Our Case Number: ABP-322166-25

Re: Proposed residential development for Corrib Causeway, Dyke Road
Corrib Causeway, Dyke Road, County Galway

Re: Submission – Corrib Causeway – Dyke Road, Galway (ACP Ref: 322166)

PROPOSED ROAD LAYOUT
(SHEET 01)

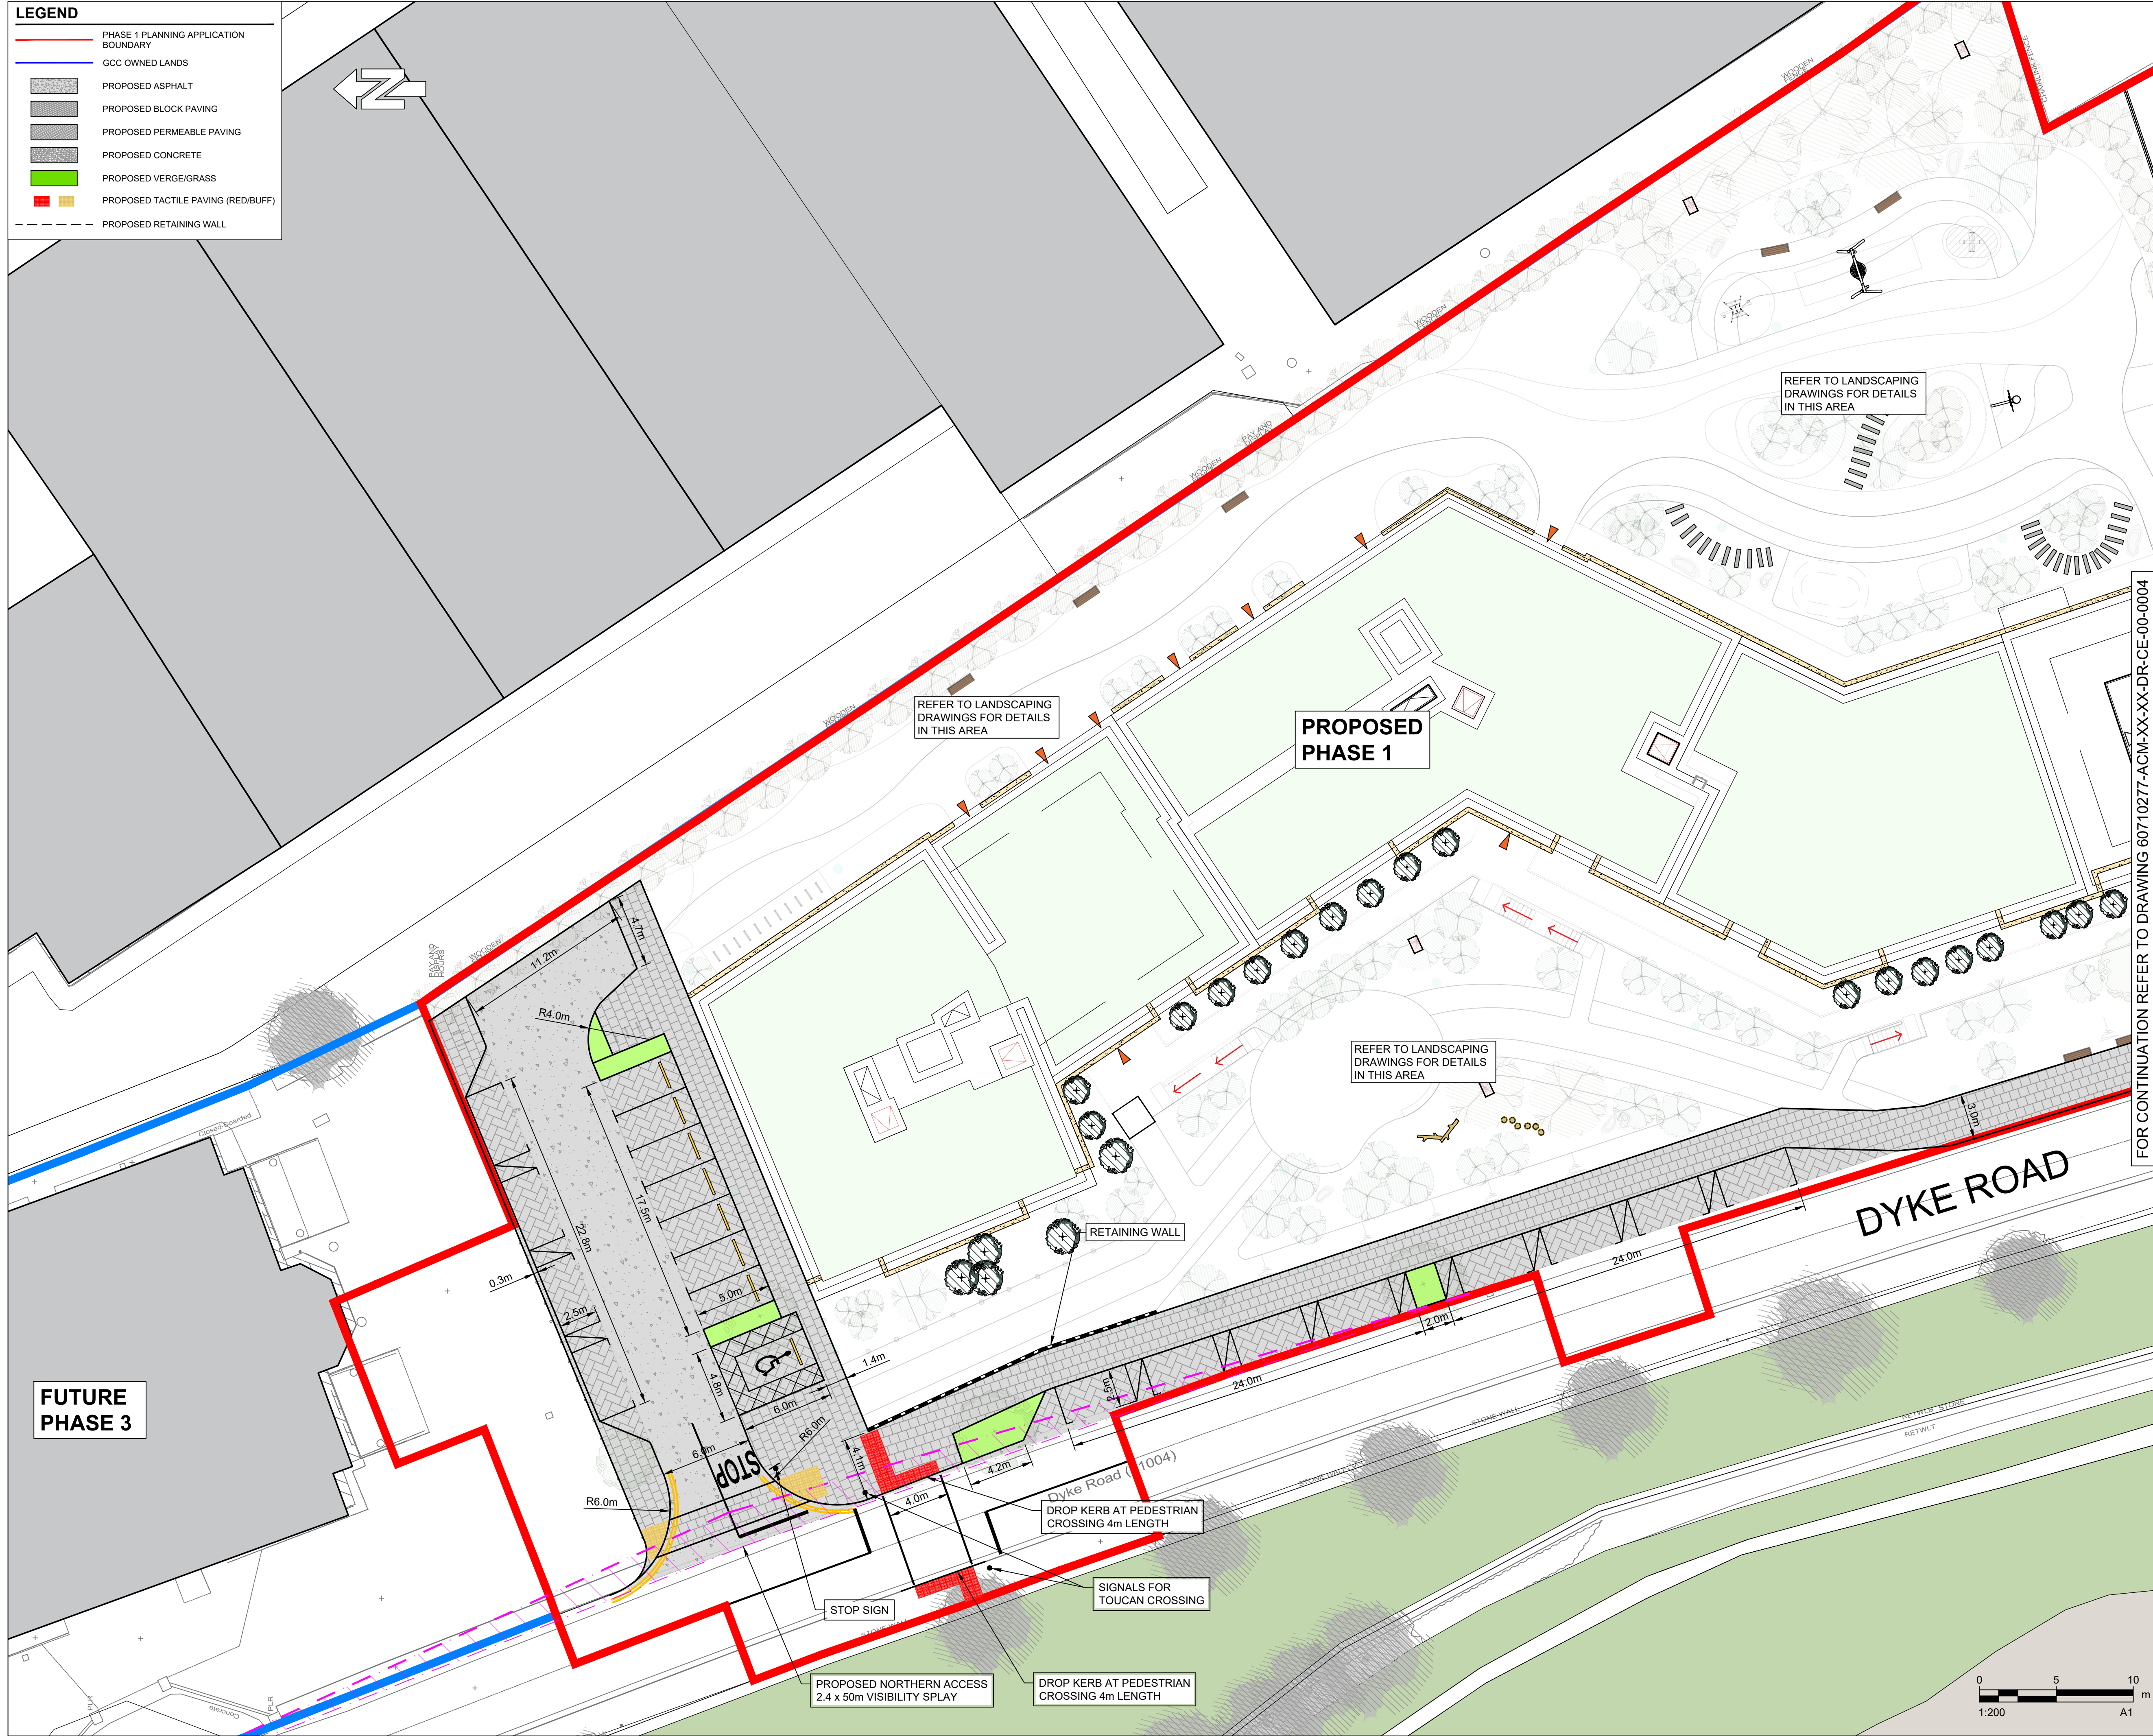
Following a review of the Response to Observations report, as submitted by GCC, we wish to again highlight that provision is made for future connectivity between the subject and Cleveson sites, and which specifically identifies pedestrian and vehicular access through the adjoining permitted student accommodation development (illustrated in Figure 1 below).

The Coimisiún will note, in the context of the permitted student accommodation development on our clients' lands, that the pedestrian/cycle movement illustrated in Figure 1 (route A) below traverses an area which comprises a 'back of house' service, delivery and staff car parking area for the adjoining Cleverson development. The Cleverson scheme is not designed to take vehicular traffic other than infrequent, controlled service vehicles to service the back of the Cleverson site. Galway City Council Road Department did not want a traffic junction at this location but accepted a single-lane width scenario for infrequent service access, which would be on a scheduled basis. This was established during the pre-planning consultation, planning application and post-planning stages of the student accommodation development with Galway City Council's Roads and Transport department. The initial site design for the student accommodation site, as agreed with Galway City Council, was for service vehicles access only due to the proximity of the access to the Lidl junction across the road and the Dyke Road Junction and to ensure low numbers of vehicles utilising the junction. Allowing through traffic movements at this location would pose a greater accident risk at the junction due to the intensification of use at the entrance onto what is essentially a 4-way priority junction. Thus, it is the understanding of our client, that the Galway City Council Road Department have not been consulted in relation to the Corrib Causeway development.

Our client appreciates the importance of an integrated movement network, and Route B illustrated in Figure 1 above, and Masterplan 1 and Masterplan 2 drawings attached, represent an example of a more appropriate route, which would connect the users closer to the city, while benefiting from passive surveillance by both the Cleverson and Corrib Causeway (phase 1 and 2) developments. This enhanced visibility, and a route absent from delivery/service vehicles would significantly improve the security of the users, and has the potential to accommodate more than infrequent service vehicles, should it be desired to do. The proposed sketches show a revised scheme of the Cleverson site, which our client is willing to accommodate in order to alter the placement of the through route. We would respectfully request that An Coimisiún Pleanála take the revised proposal into consideration, and consider whether the design of the proposed development, specifically in terms of the provision of linkages through the Cleverson site, constitutes an optimum or appropriate arrangement.

Drawing file: Drawings / 60710277-ACM-XX-XX-DR-CE-10-0500_P3_01_ProposedDrainage.pdf

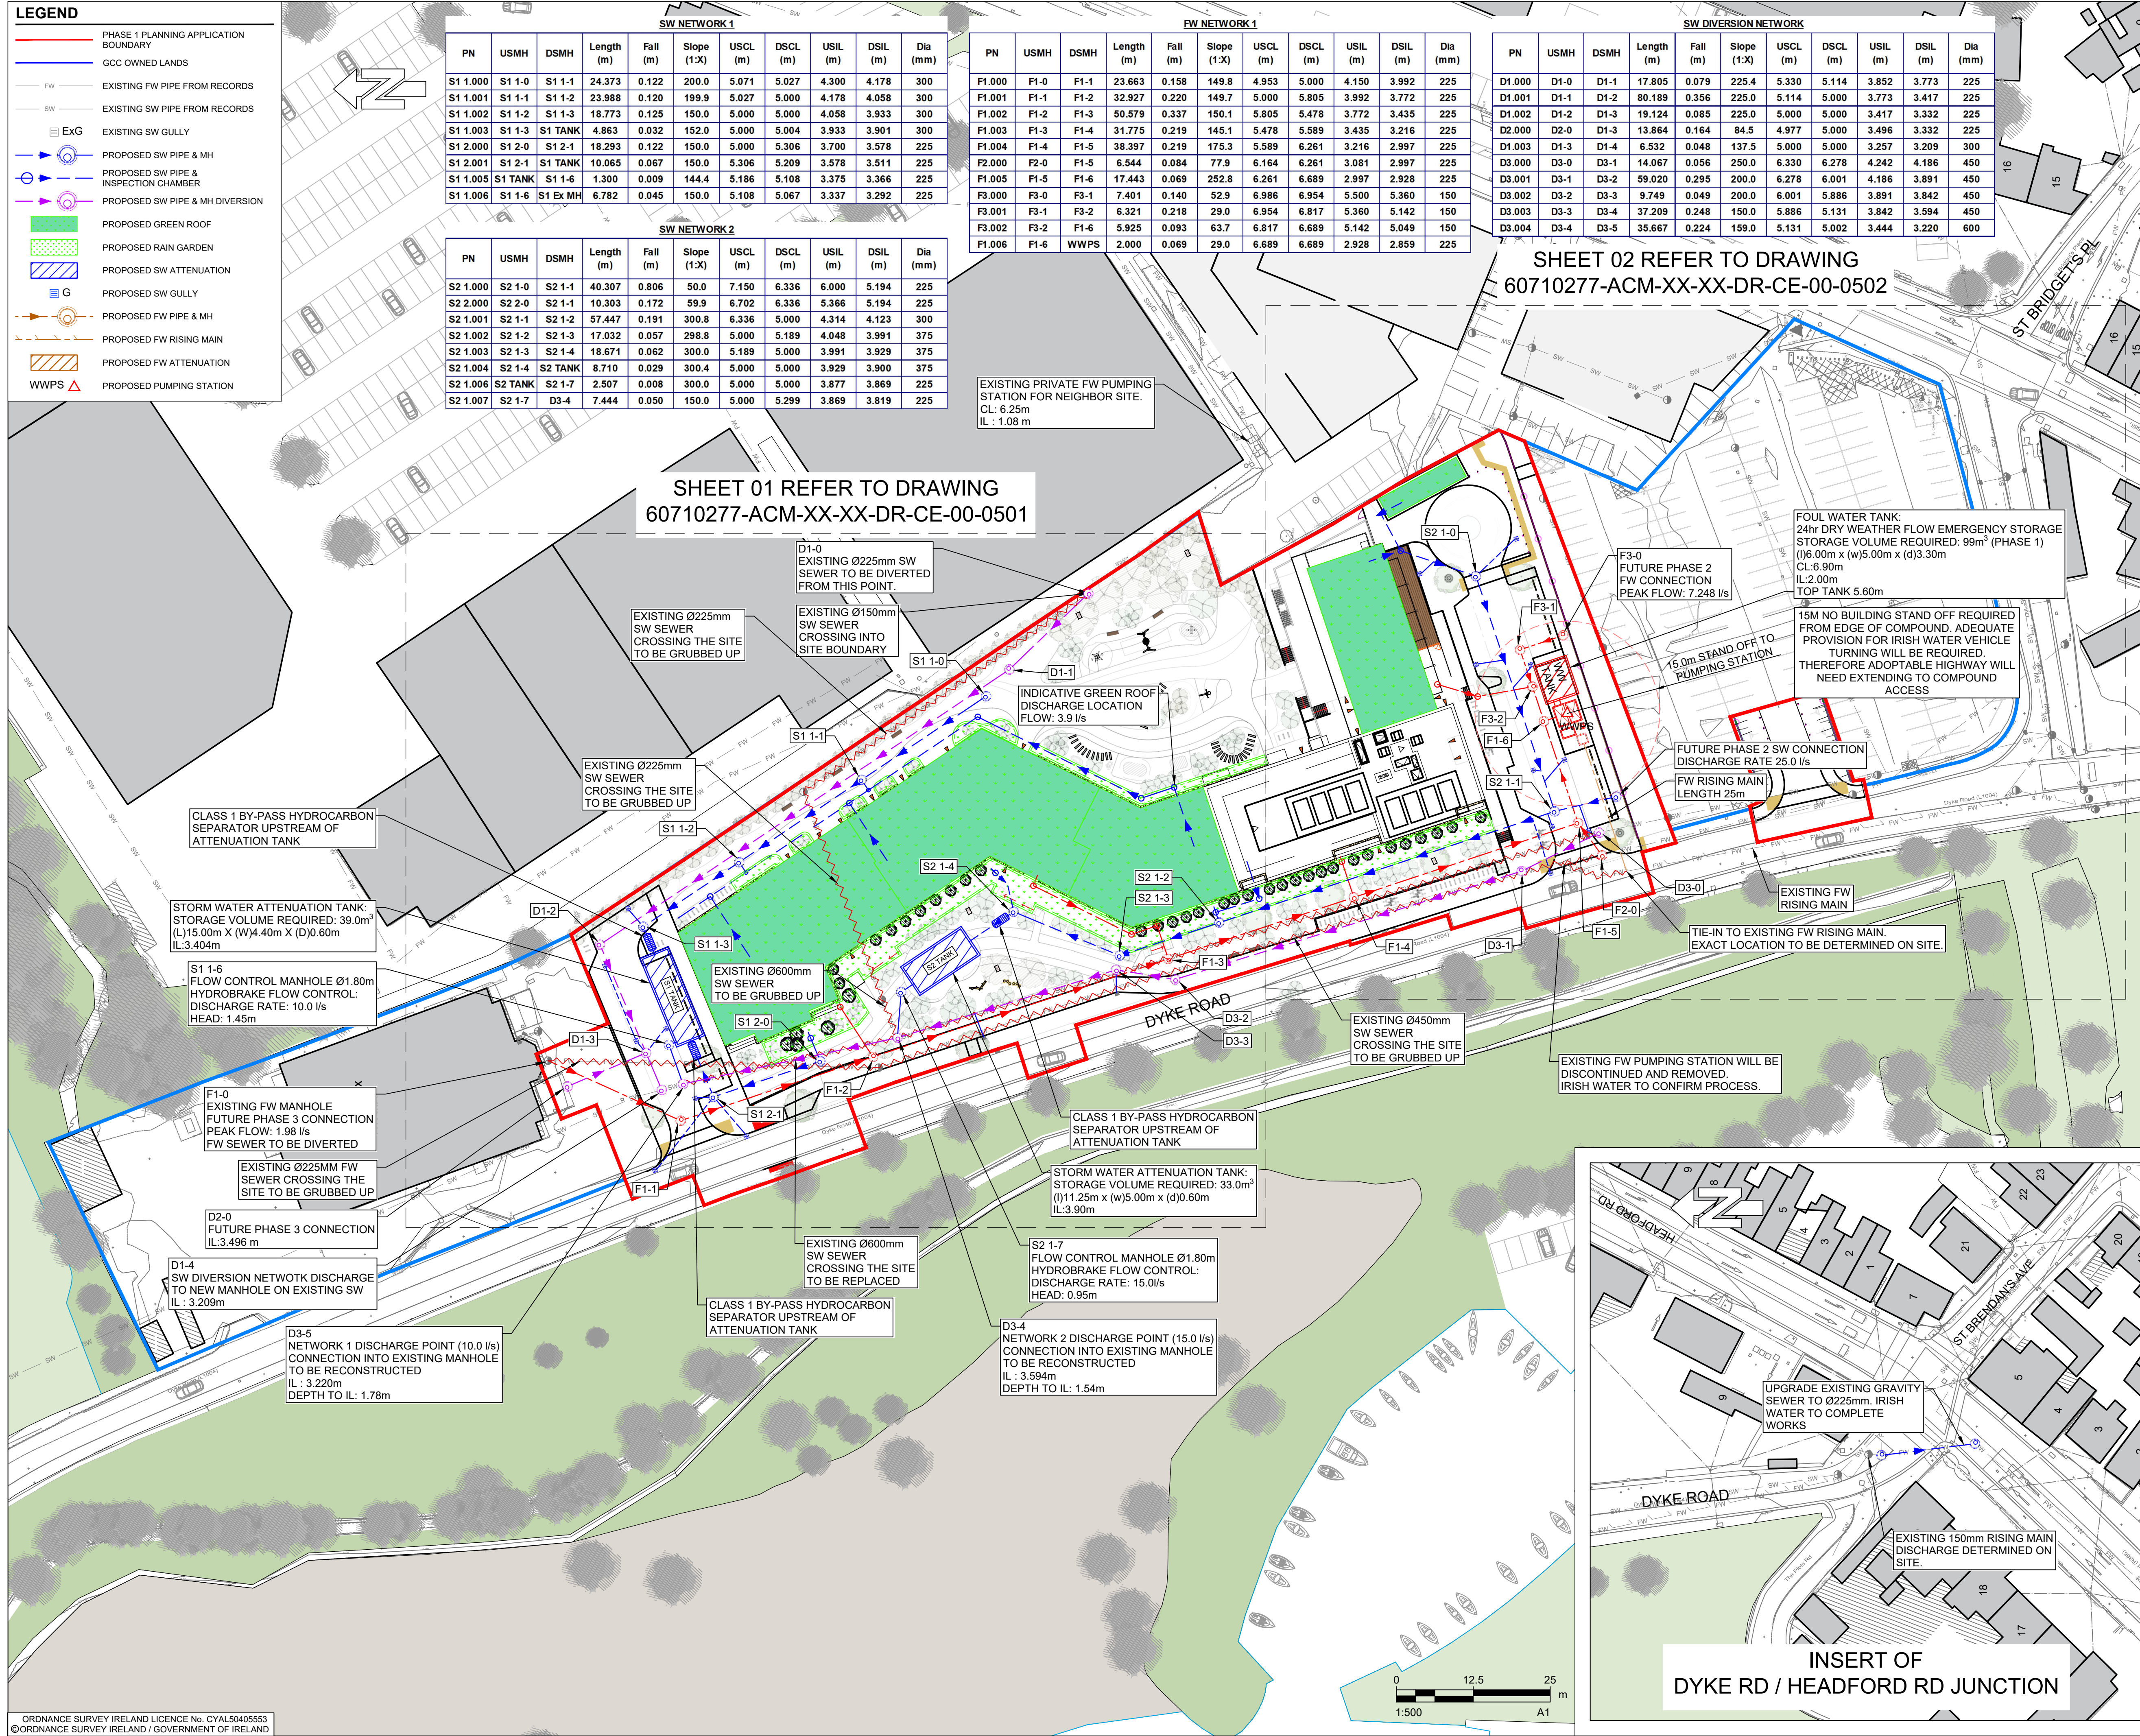
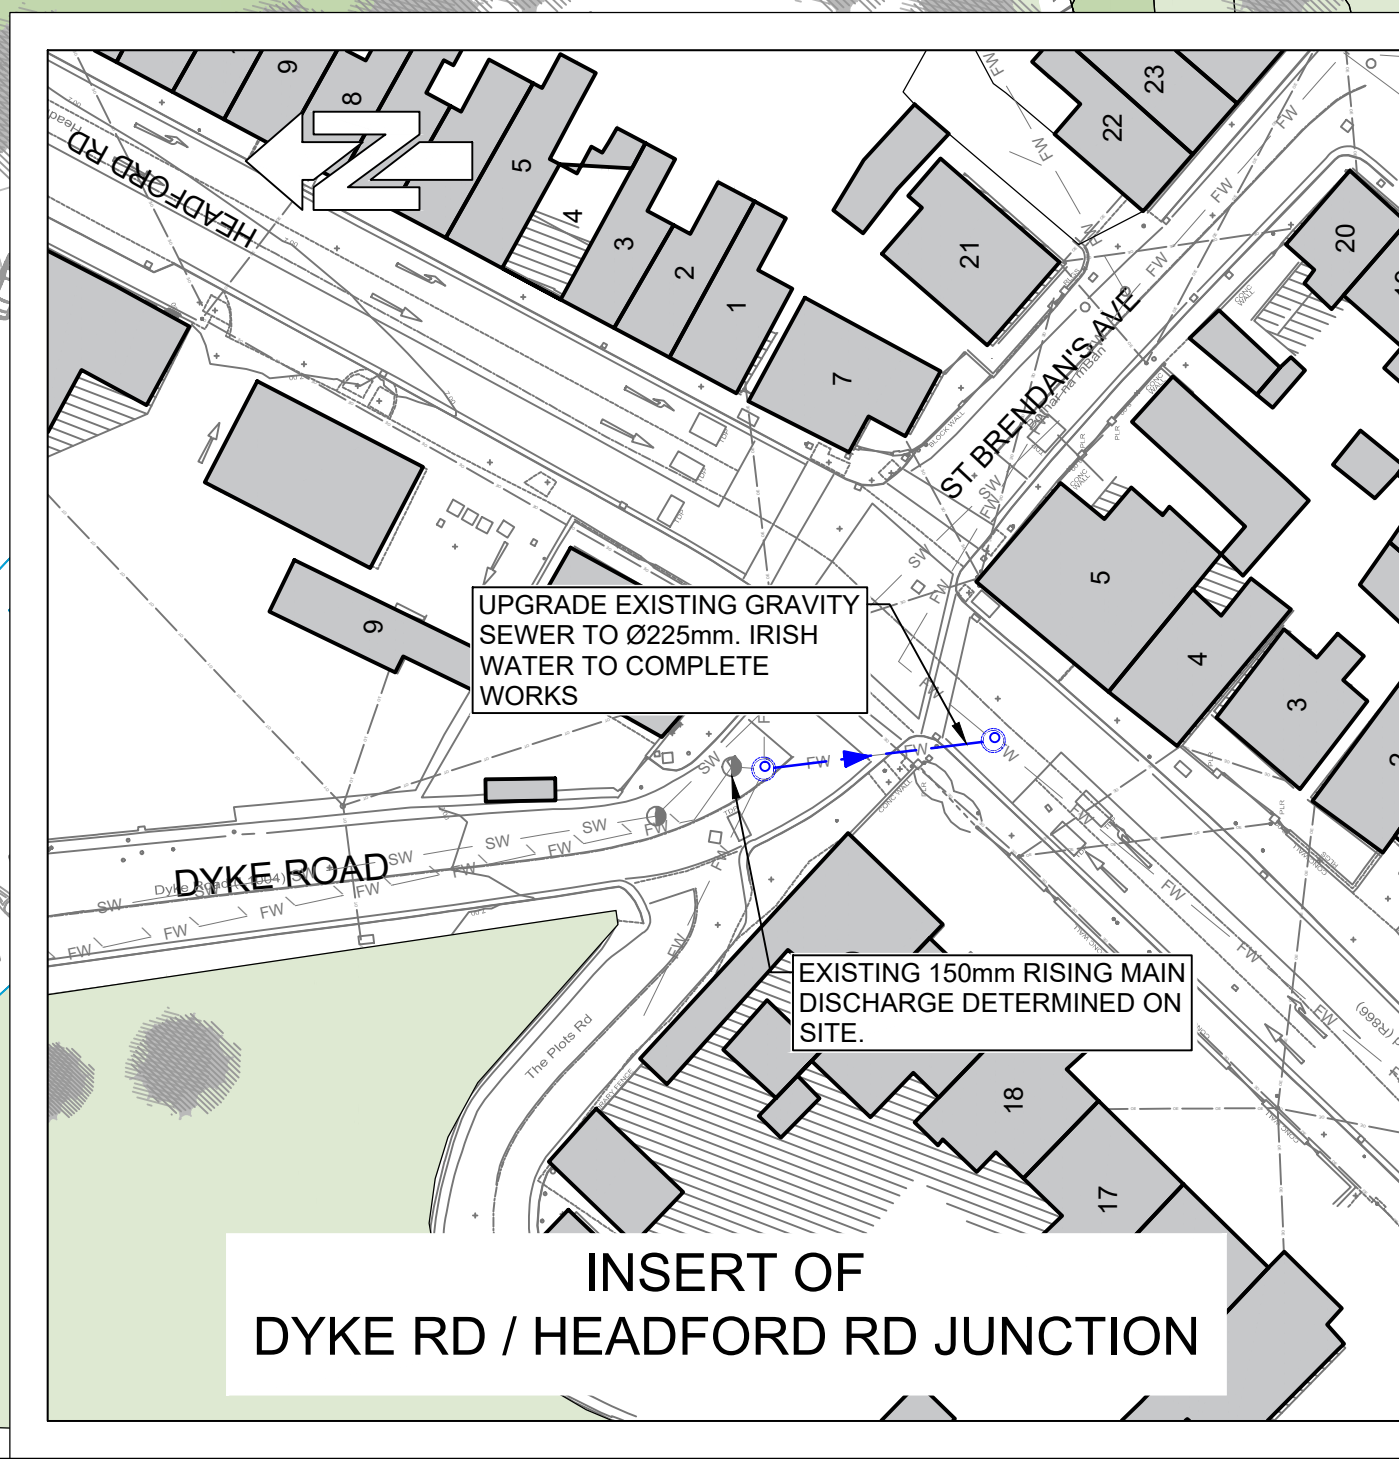
The proposed Corrib Causeway development positions new residential blocks only 6-7 m from the permitted Cleverson pumping station, falling short of the 15m implied separation required under Uisce Éireann's Code of Practice for Wastewater Infrastructure (Section 5.5). Reliance on window levels, diagonal dimensions or internal layouts cannot substitute for this logical implied prescribed clearance. We would respectfully request that the Coimisiún acknowledges the proximity of habitable buildings within the proposed Corrib Causeway development to the permitted wastewater pumping station and

satisfies itself that sufficient mitigation measures are being taken to ensure that no issues may arise as a result.

A practical solution may include for Causeway pumping station to be designed with sufficient capacity and storage to also serve the Cleveson development, allowing the permitted Cleveson station to be omitted. This would resolve the compliance issue, prevent the construction of two stations in close proximity and deliver a single, efficient and future-proofed drainage solution. Such an approach reflects good planning practice and aligns with Uisce Éireann's preference for efficient and consolidated infrastructure delivery.
